Application by Morecambe Offshore Wind Limited for Morecambe Offshore Windfarm Generation Assets

The Examining Authority's additional written questions and requests for information (ExQ3)

Issued on 25 March 2025

6 Liverpool Bay SPA with 2.4nm CPP1 WTG and OSP Aviation Buffer and 1.9nm Calder WTG and OSP Buffer

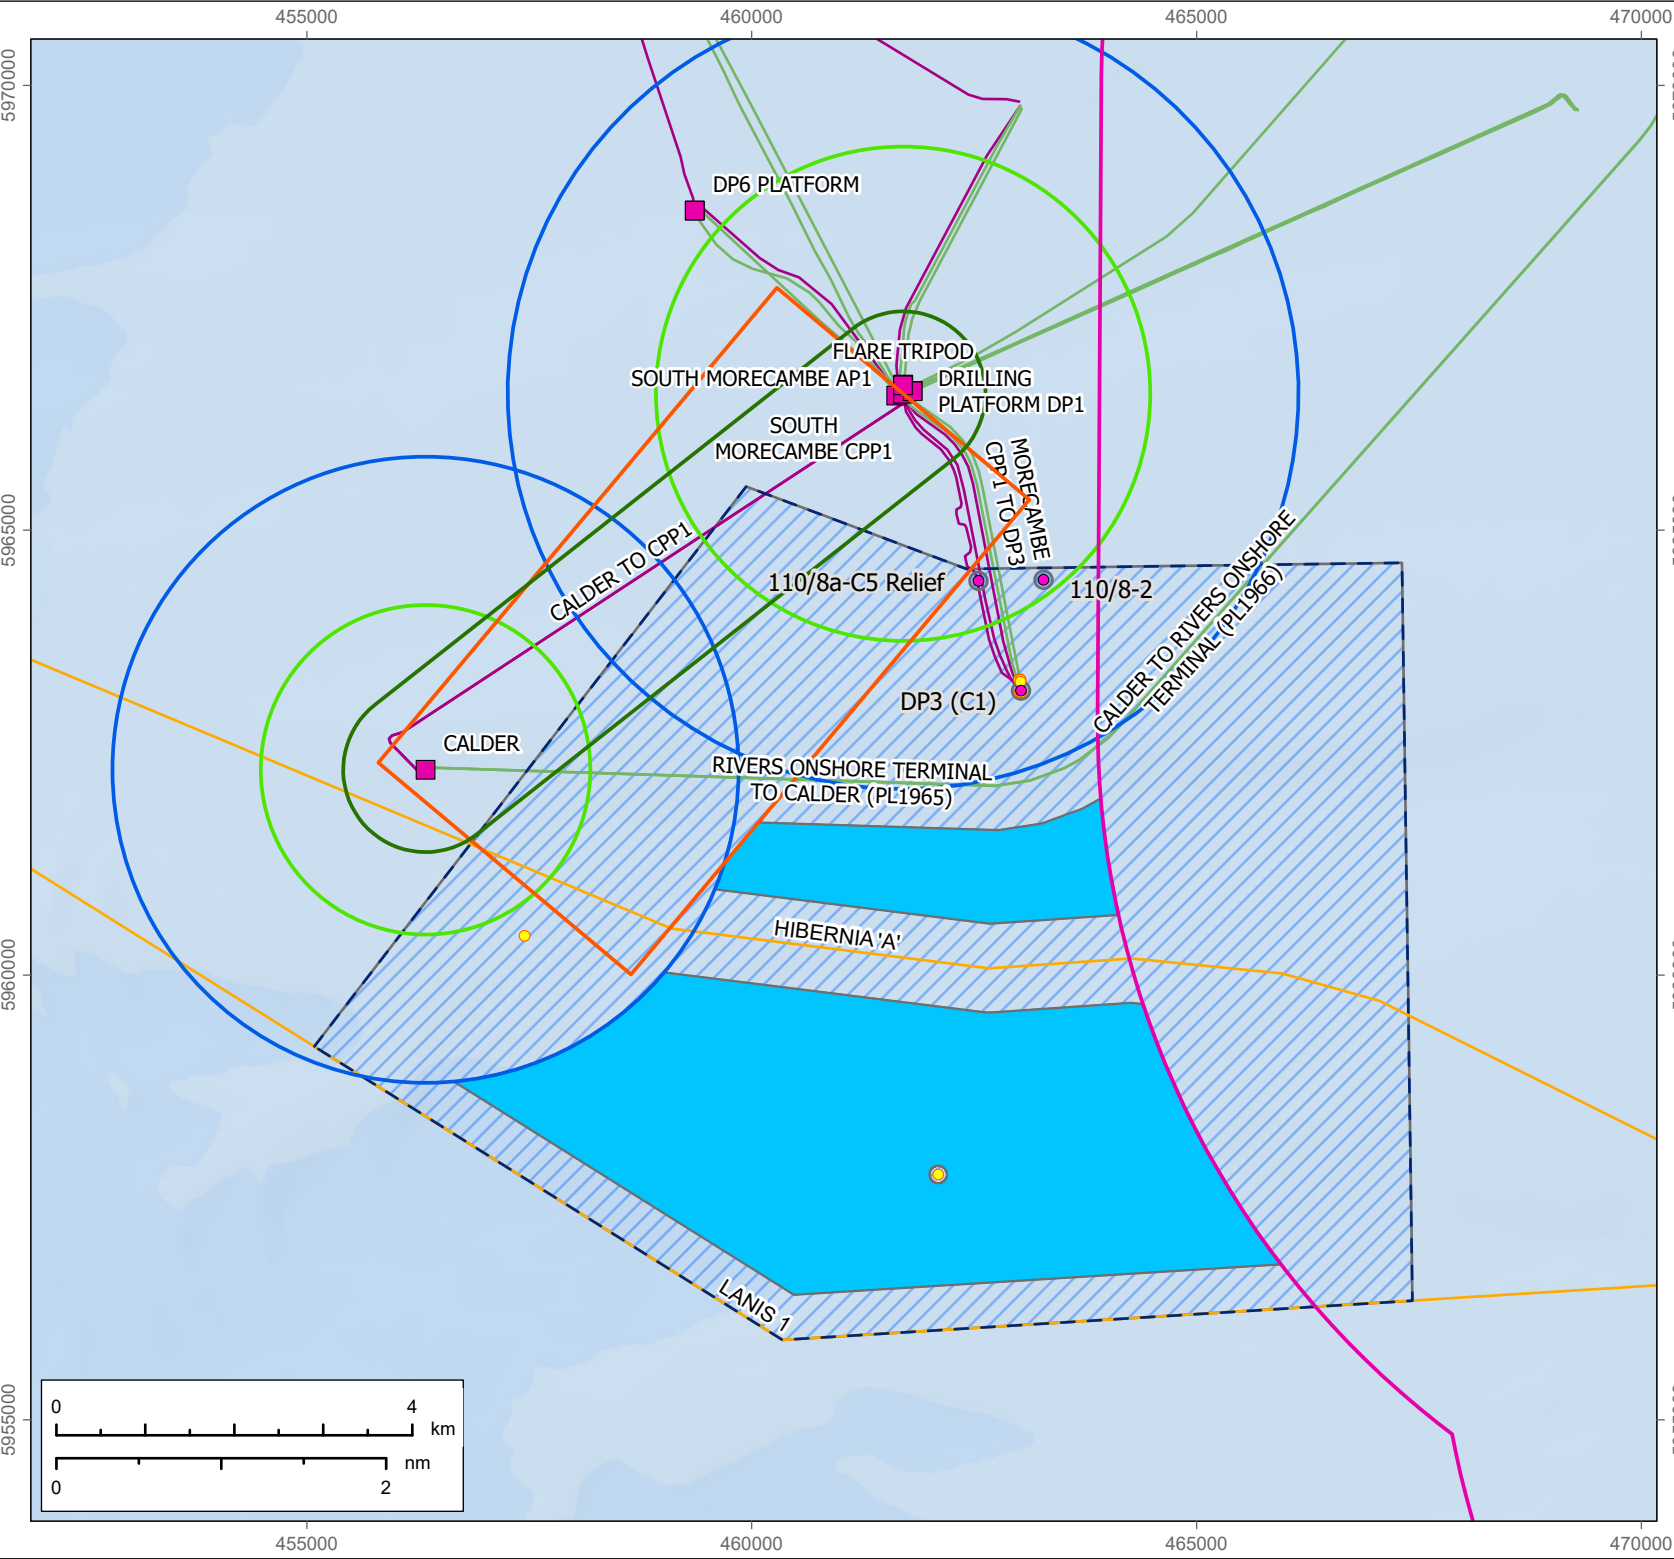
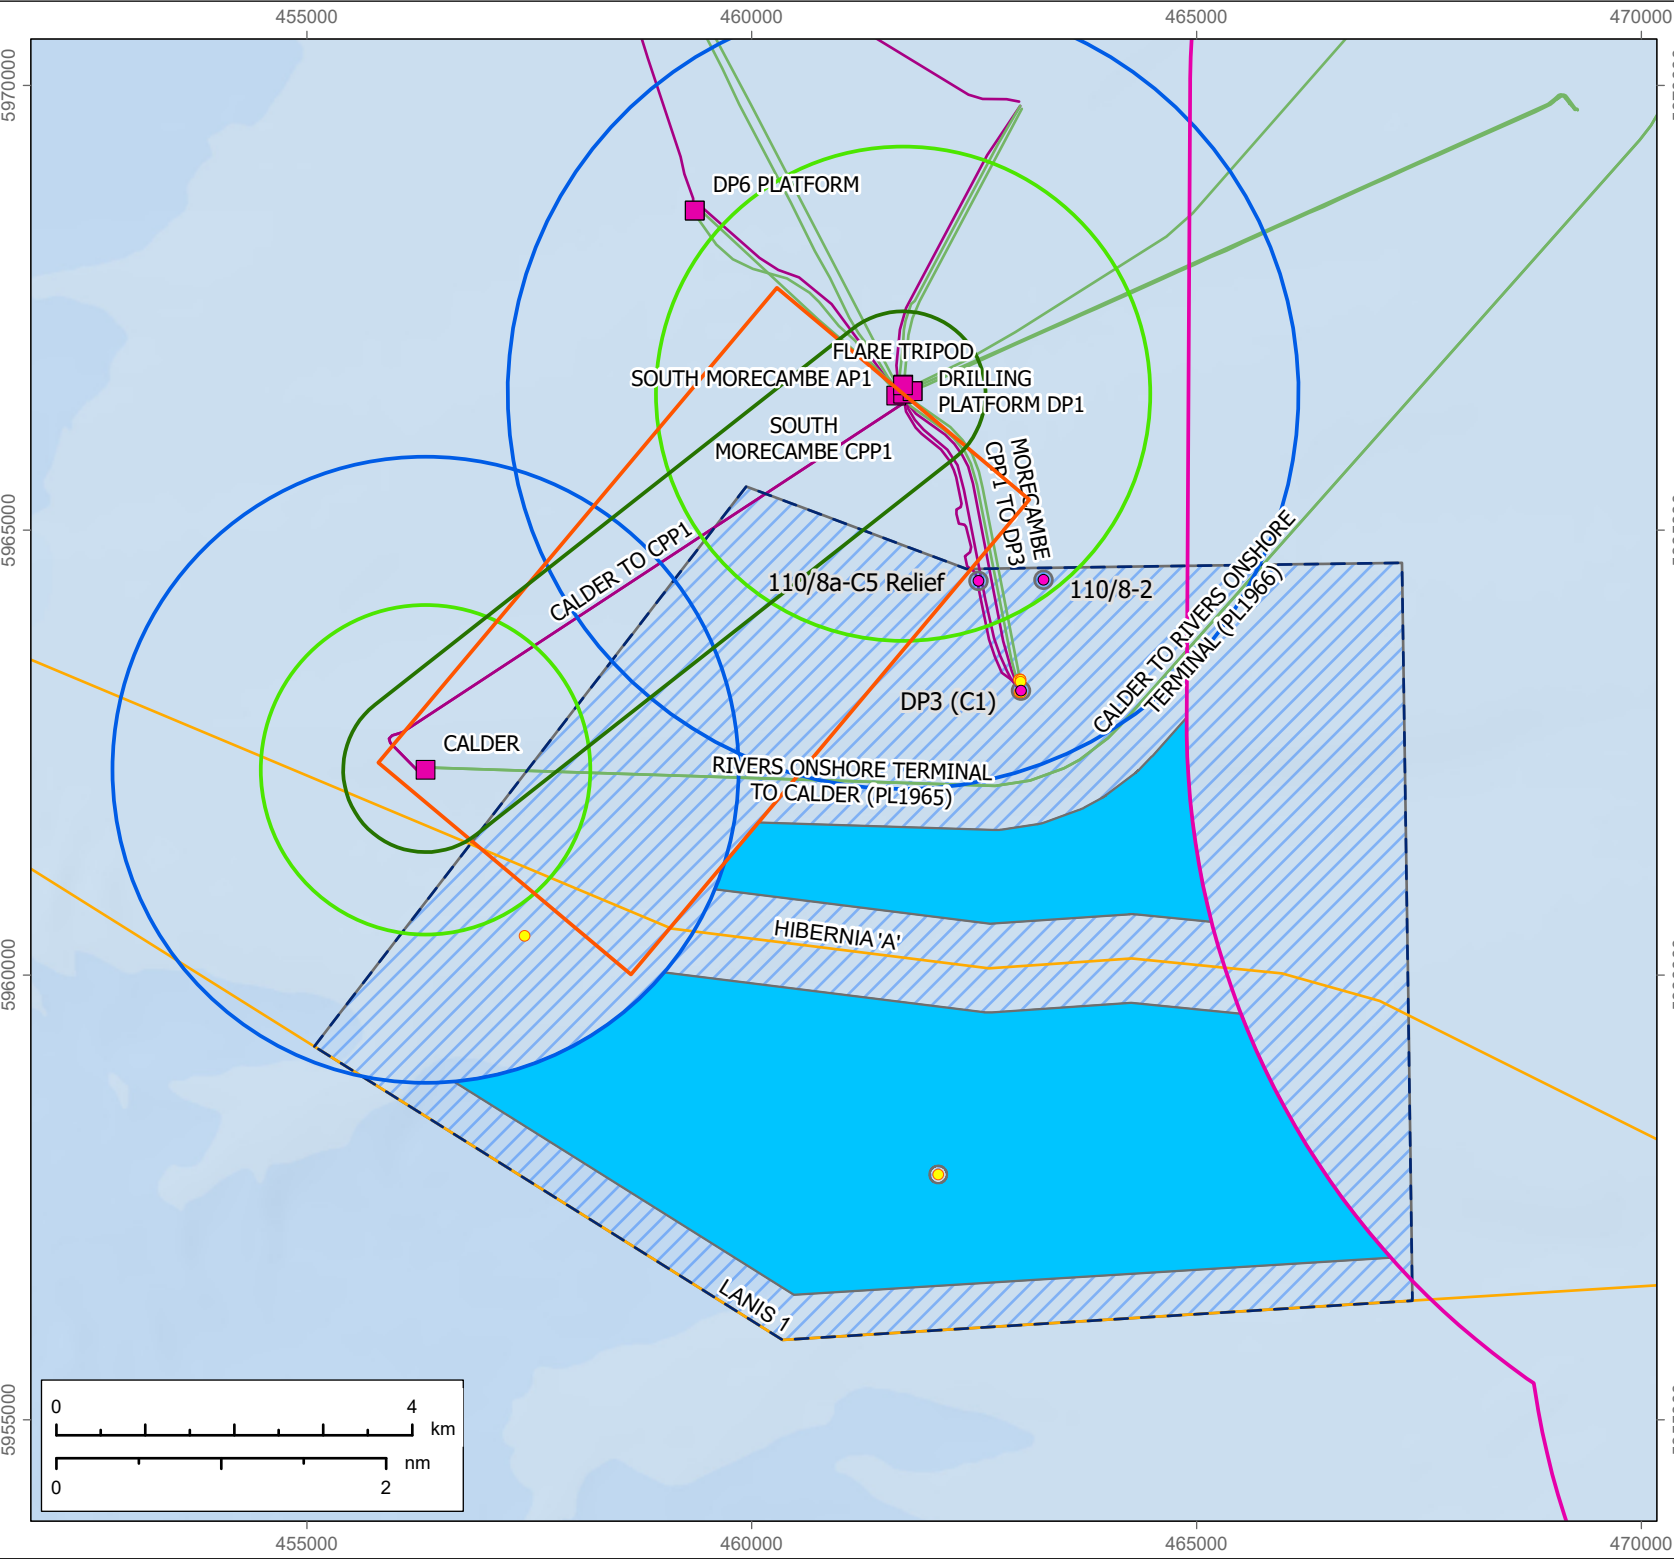
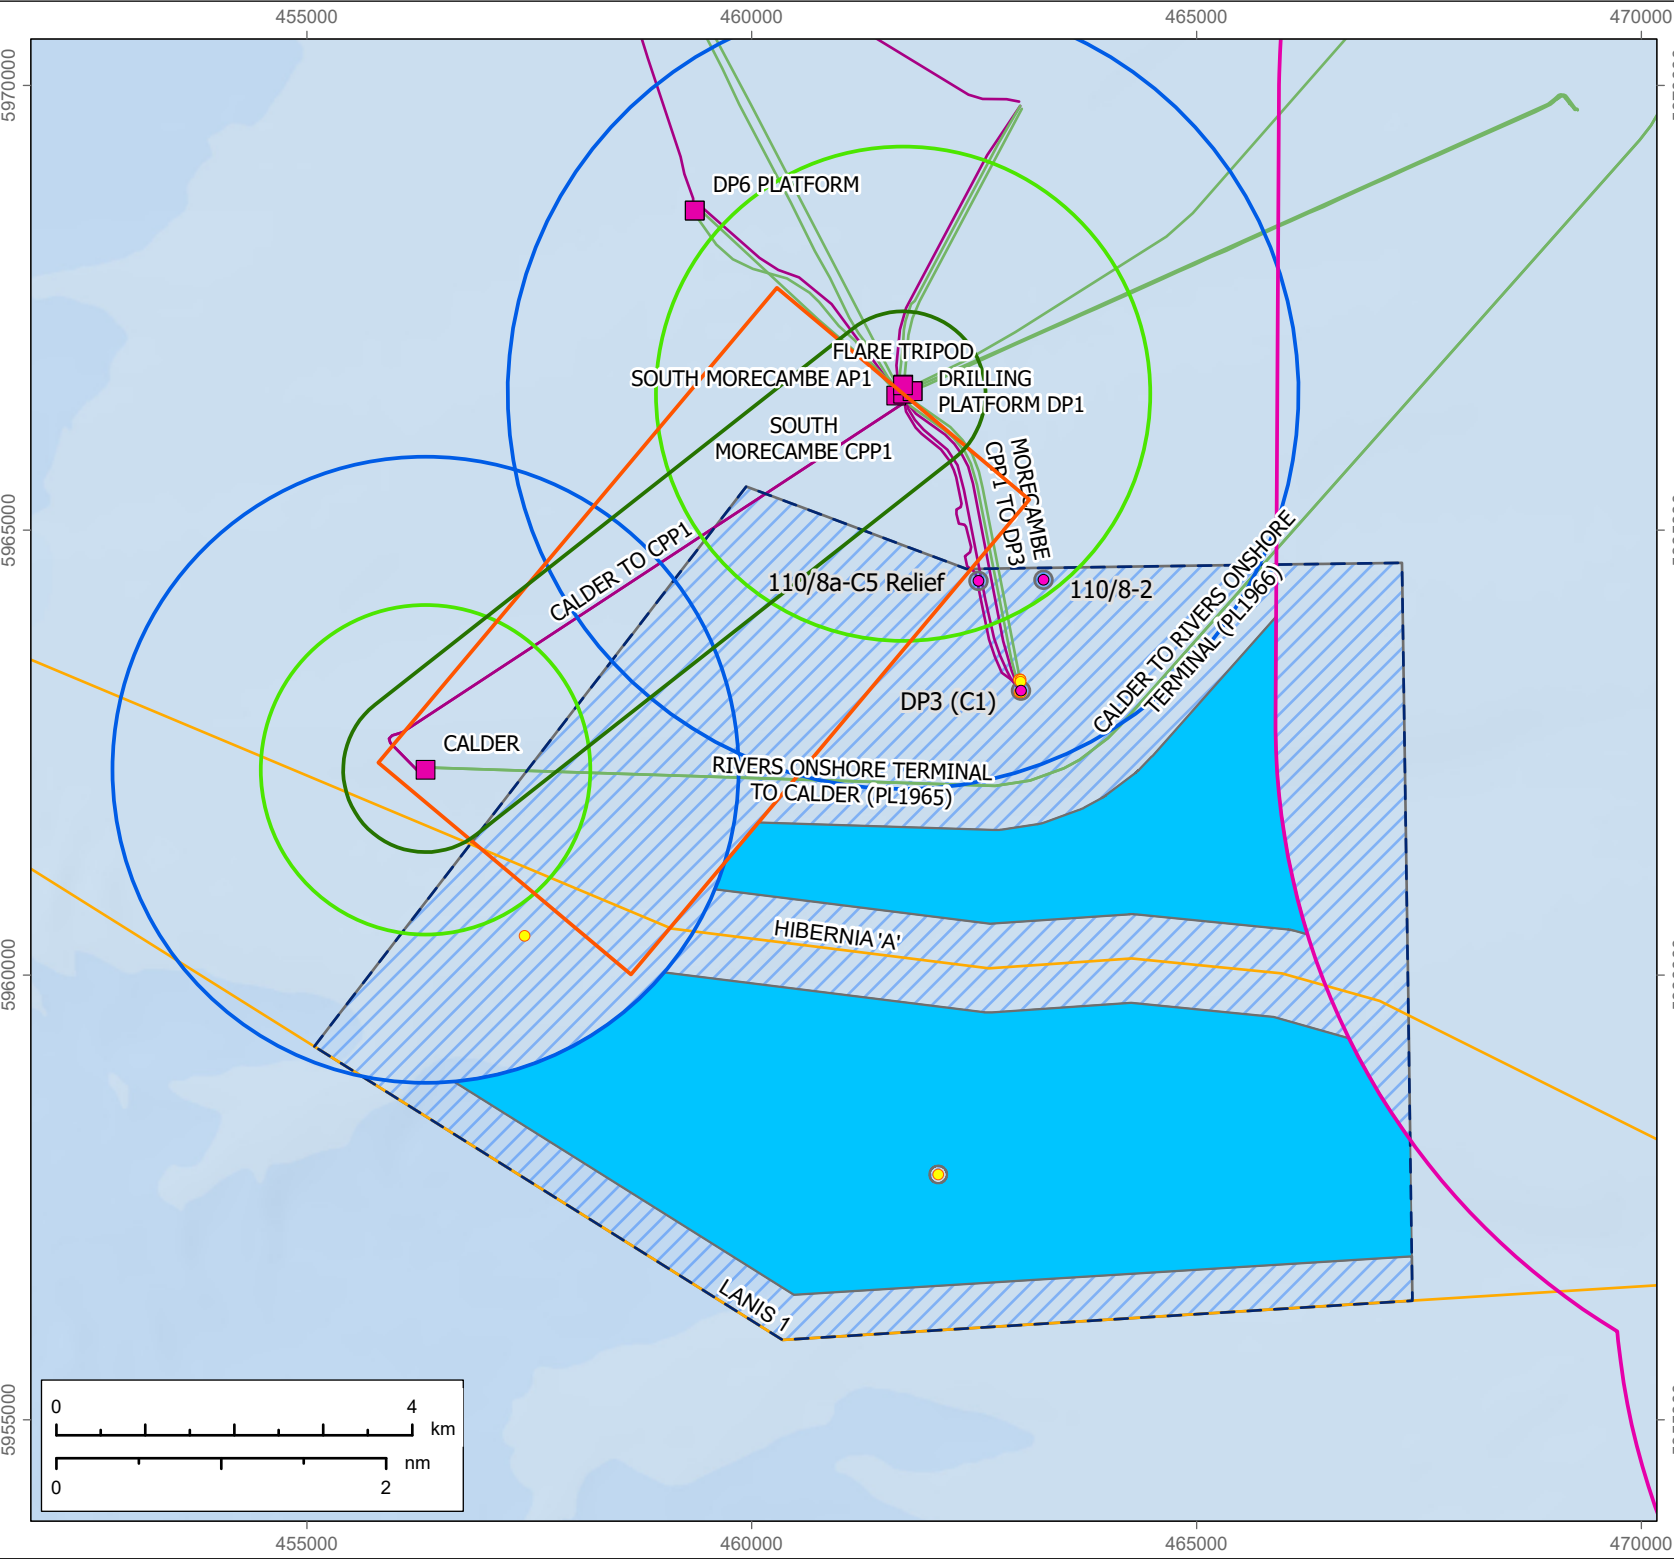
ExQ3	Question to:	Question:										
3GEN3.	The applicant	<p>Liverpool Bay SPA and Oil and Gas Platform Buffers</p> <p>Whilst the ExA notes the caveats stated in the applicant’s response to ExQ2HRA6 at D5 [REP5-070], to further demonstrate and support the applicant’s position:</p> <p>a) please can the applicant provide individual plans to demonstrate the impact that each of the incrementally smaller buffers from the original Liverpool Bay SPA would have on the layout and number of WTGs that could be accommodated within the site (i.e. 10km, 9km, 8km, 7km and so no buffer associated with the SPA affects the site) - with all other existing buffers/ corridors as shown on [REP5-007] unchanged.</p> <p>b) in Spirit Energy’s response to ExQ2CAR5 at D5 [REP5-090] it advises a buffer distance of 1.9nm is the minimum acceptable requirement for safe landing and take-off in daytime VMC and for night VMC this distance would be 2.4nm. In light of this could the applicant provide plans for each alternative SPA buffer scenario in (a) plus each of the increased buffer scenarios from the Calder and CCP1 platforms as set out in the following table.</p>

<table><tr><th><u>CPP1 WTG and OSP Aviation Buffer</u></th><th><u>Calder WTG and OSP Buffer</u></th></tr><tr><td>2.4nm</td><td>1.9nm</td></tr></table>

<p>c) any additional comments or further information the applicant wishes to provide on the implications of each of the above scenarios (noting the applicant’s previous response [REP5-070], EXQ2HRA3 and 2HRA6].</p> <p>The ExA is seeking a complete set of alternative scenarios shown on plans, so that, whatever the SoS may determine, if they felt it was appropriate they could include the relevant plan within any final DCO without having to revert to the applicant for that plan. Each should therefore have a different drawing number.</p>	<u>CPP1 WTG and OSP Aviation Buffer</u>	<u>Calder WTG and OSP Buffer</u>	1.9nm	1.9nm	2.4nm	1.9nm	1.9nm	2.4nm	2.4nm	2.4nm
<u>CPP1 WTG and OSP Aviation Buffer</u>	<u>Calder WTG and OSP Buffer</u>											
1.9nm	1.9nm											
2.4nm	1.9nm											
1.9nm	2.4nm											
2.4nm	2.4nm											
3GEN4.	The applicant	<p>Design Statement - Cabling</p> <p>Could the applicant please explain why (former) provision DC15 relating to use of the most direct/ efficient cabling route to minimise cutting has been deleted from the post-consent design code in Table 6.1 of the Design Statement [REP5-008] and [REP5-009].</p>
